RE: LAND SOUTH OF SOUTH SIDE, STEEPLE ASTON

Please find enclosed an application made by Rectory Homes proposing a non-material amendment to approved application 22/01788/F. The application has been submitted via the Planning Portal (ref: PP-12270868).

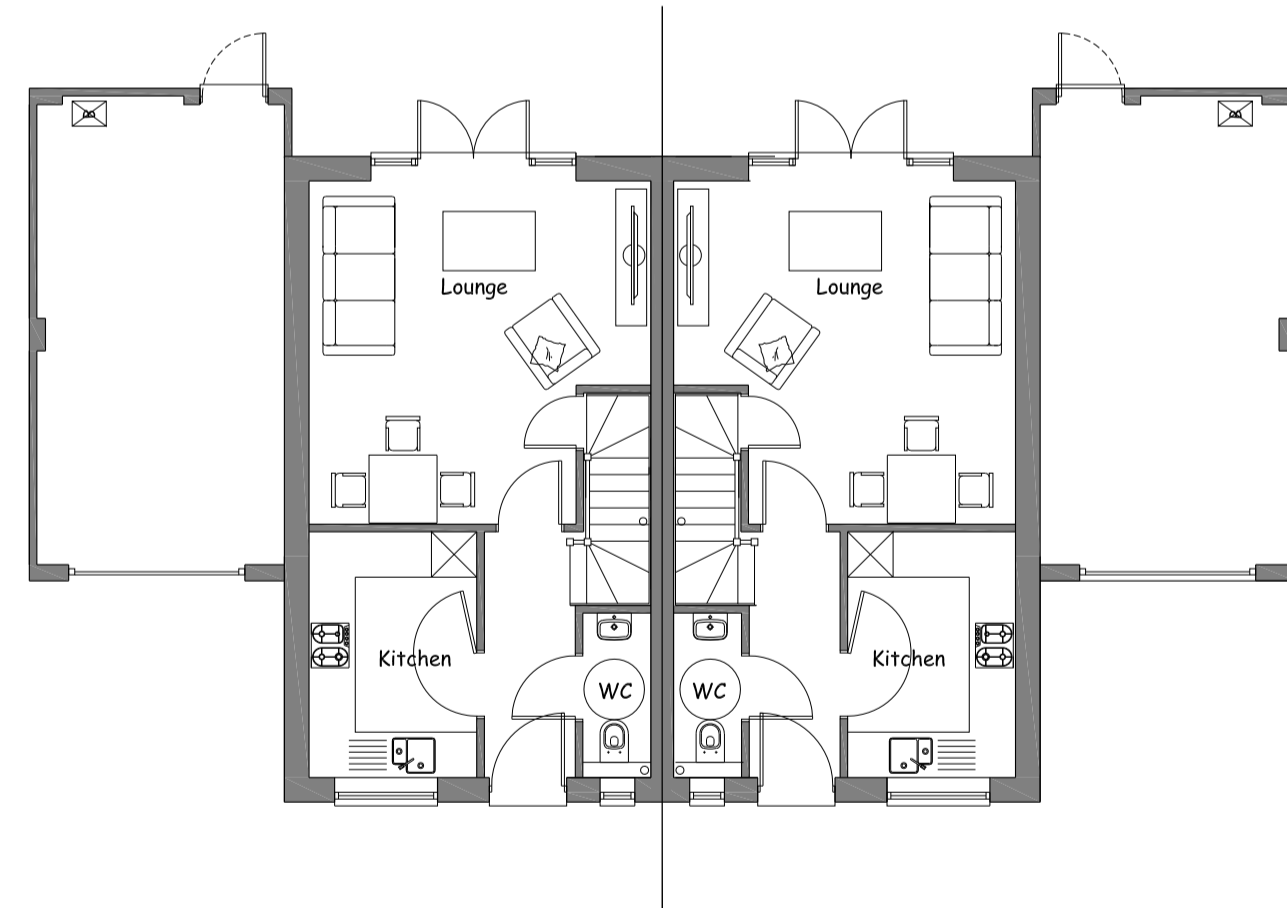
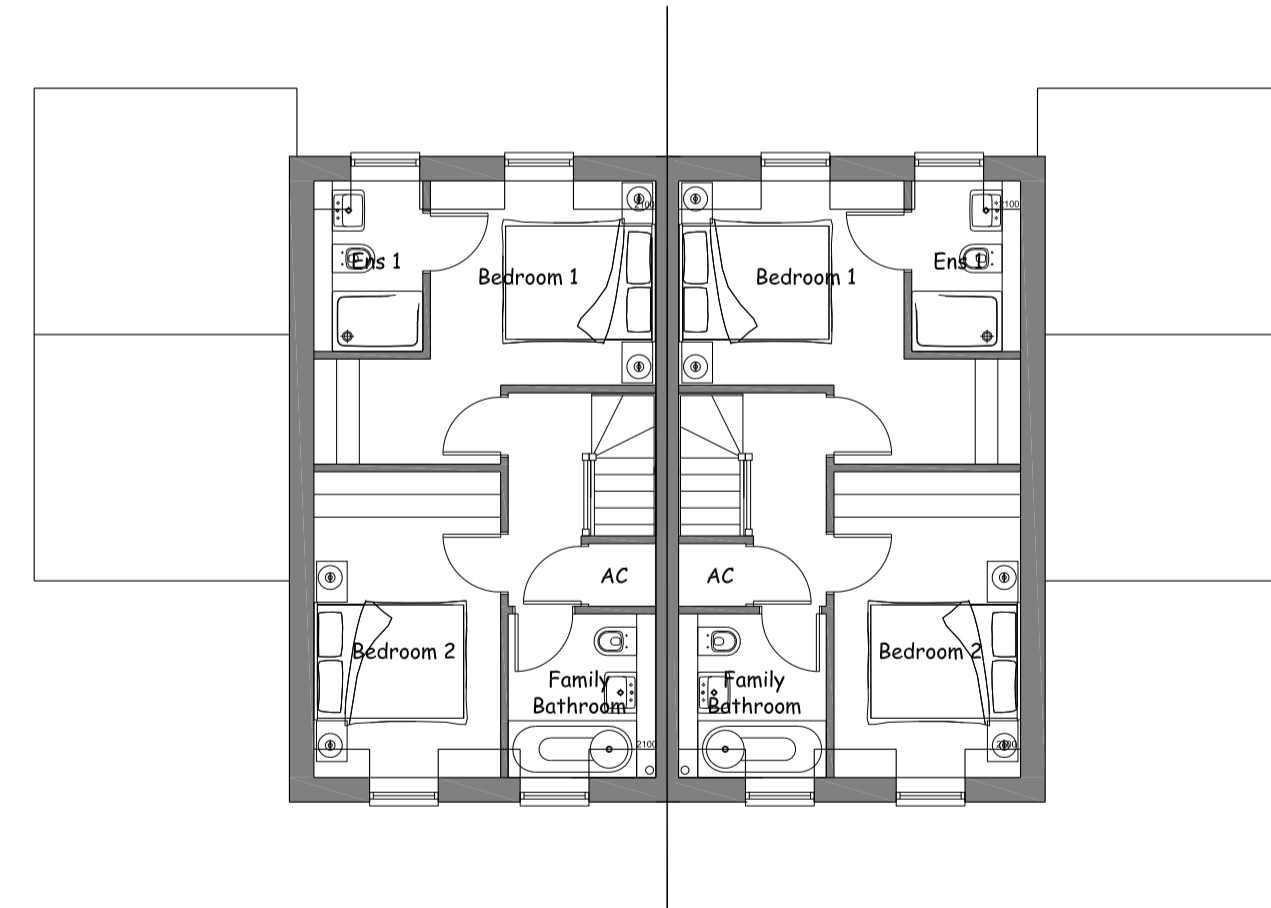
Rectory Homes are seeking approval of an amendment to the approved plans to show a step-change in ridge height between plots 8 and 9. Whilst the elevation plans for these dwellings approved as part of the full planning permission show the ridge heights of these dwellings as flush, the approved drainage details submitted to discharge condition 5 indicate a 300mm difference in finished floor levels between these two dwellings resulting a slight variance of ridge height. Condition 5 has been fully discharged by the local planning authority.

This application therefore seeks to regularise the ridge height variance between plots 8 and 9 through the submission of amended elevation plans.
